Application for a non-material amendment following a grant of planning permission.

Extension to Existing Cottage, Utilising the Footings From an Extant Permission

Reference number: 3/2017/0062

Amendment to Window in Link Element, East Elevation.

EAST ELEVATION

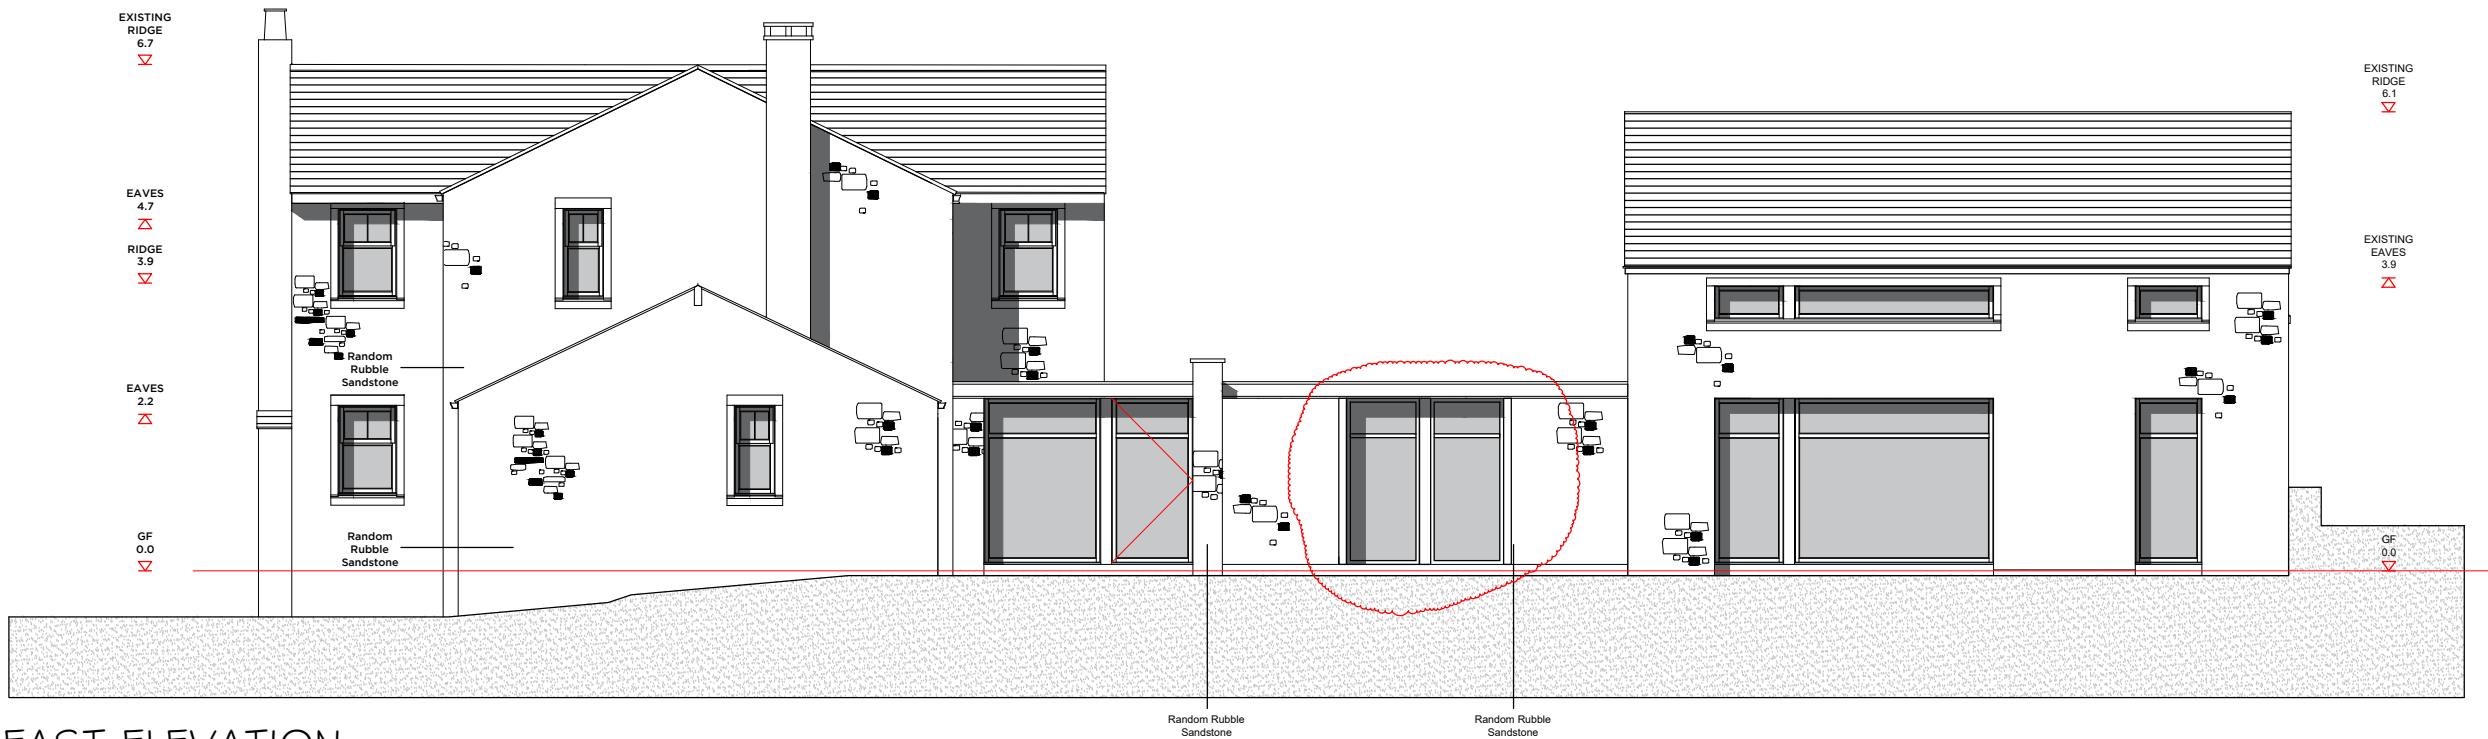
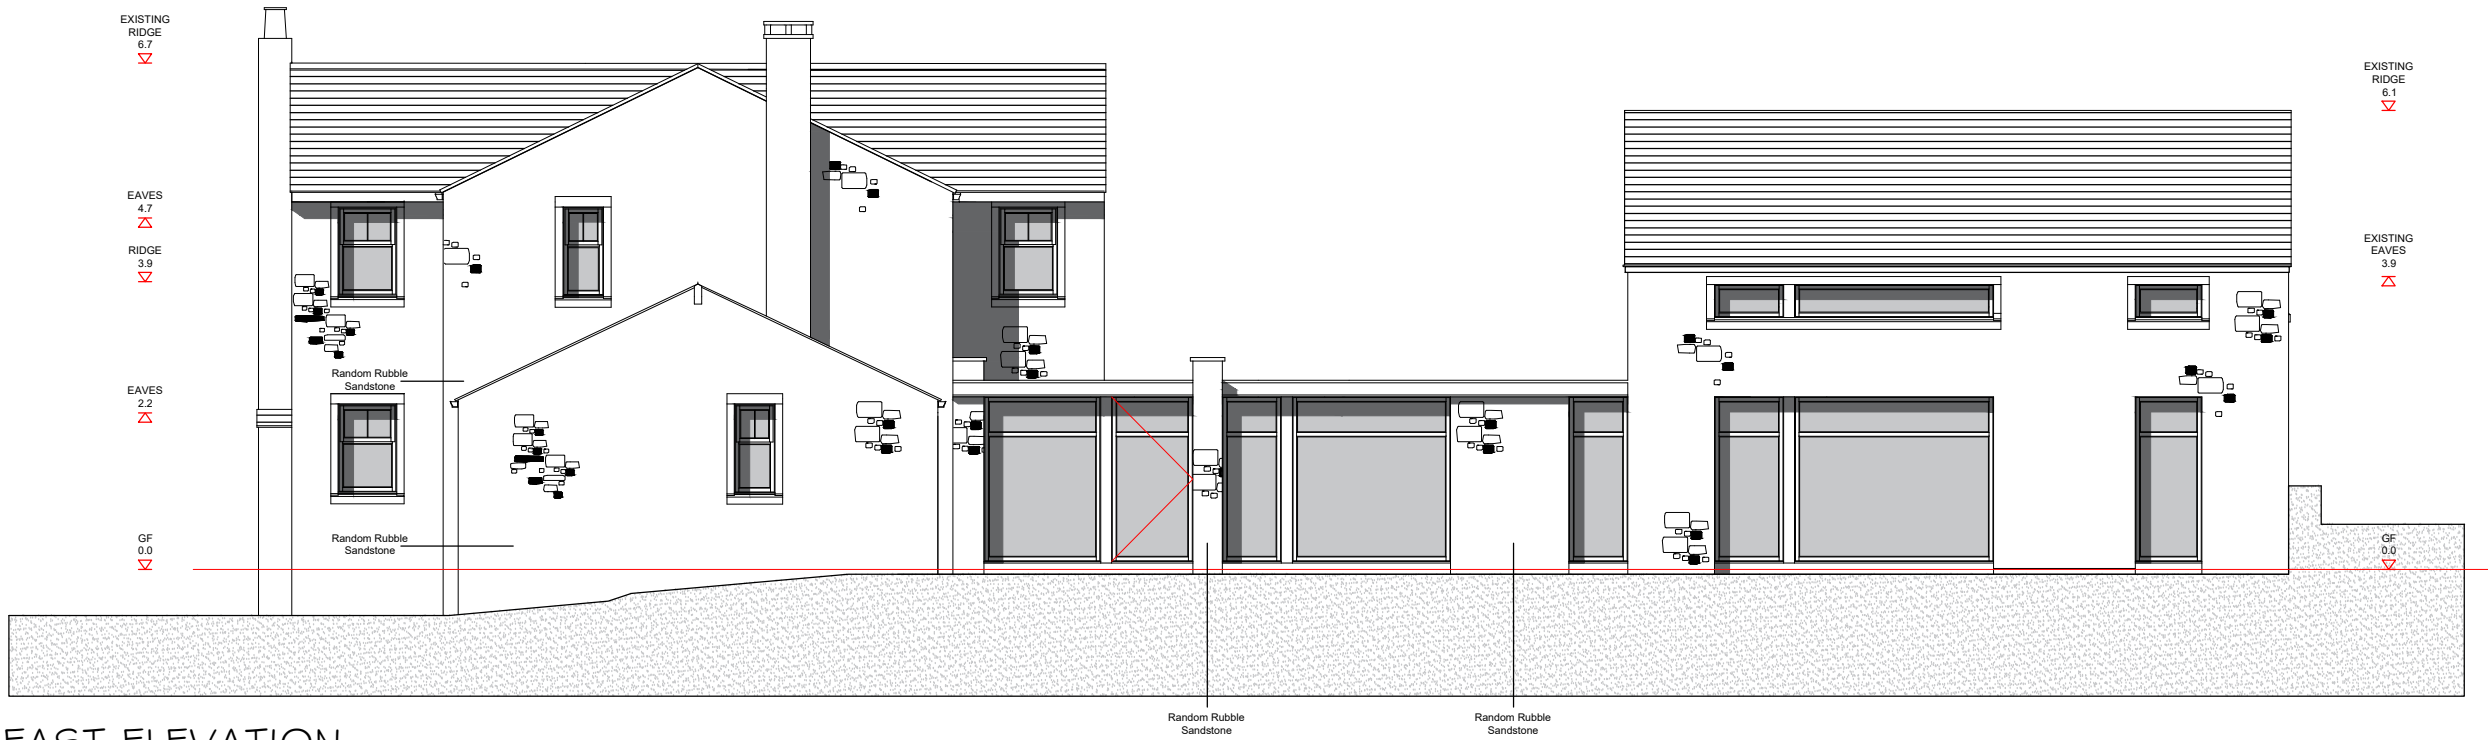
To reduce the amount of Glazing within the Link, Creating More Usable Internal Space.
